From: Jonathan Best <Jonathan.Best@arun.gov.uk>
Sent: 29 April 2025 14:44
To: Planning.Responses <Planning.Responses@arun.gov.uk>
Cc: Amber Willard <Amber.Willard@arun.gov.uk>
Subject: BN/46/25/PL

Land South of Wandleys Lane Eastergate PO20 3SE.

I have reviewed this application with regards to ecology and Biodiversity Net Gain.

**Figure 2.** Proposed site plan (VIVID Design Studio, Drawing No: 230010\_05).

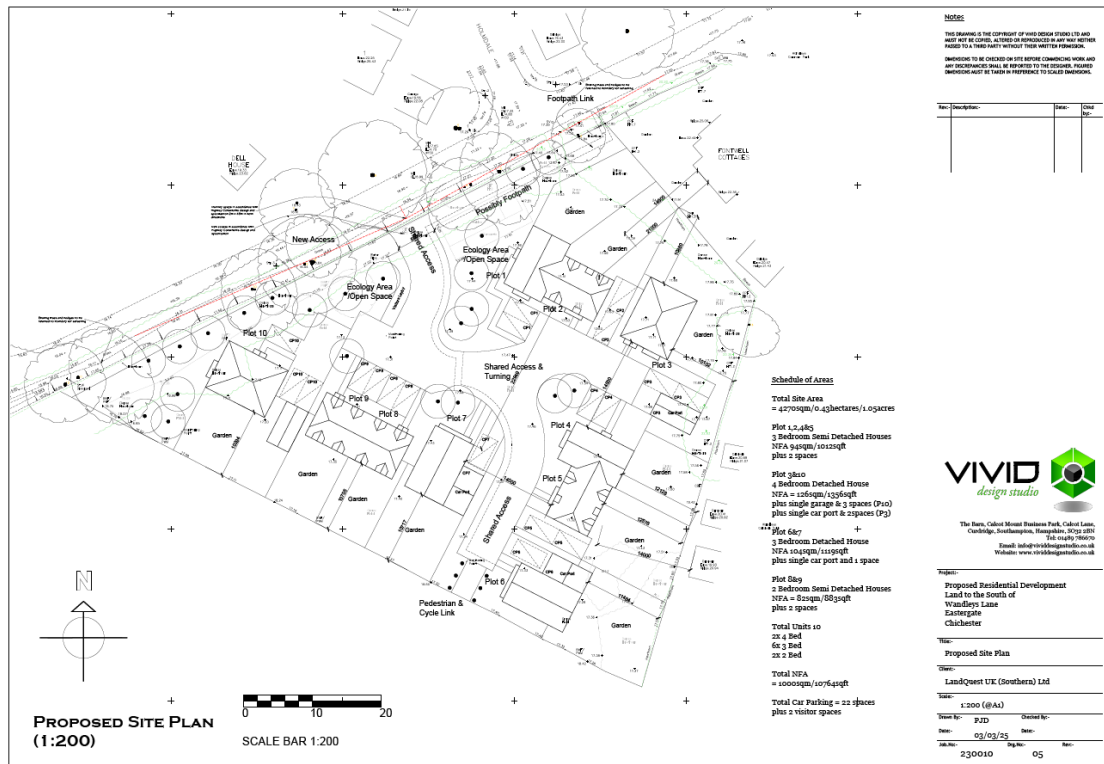
The metric calculations and BNG HMMP include enhancement of modified grassland to other neutral grassland delivering 0.40 habitat units however, the landscape plans show 20 trees proposed for the same areas.

If the trees are planted on the modified grassland the enhancement to other neutral grassland is unlikely to be successful especially as the tree planting aims to provide a continuous canopy. This requires clarification as failure to deliver the grassland enhancement would mean that the development could fail to meet the minimum 10% net gain.
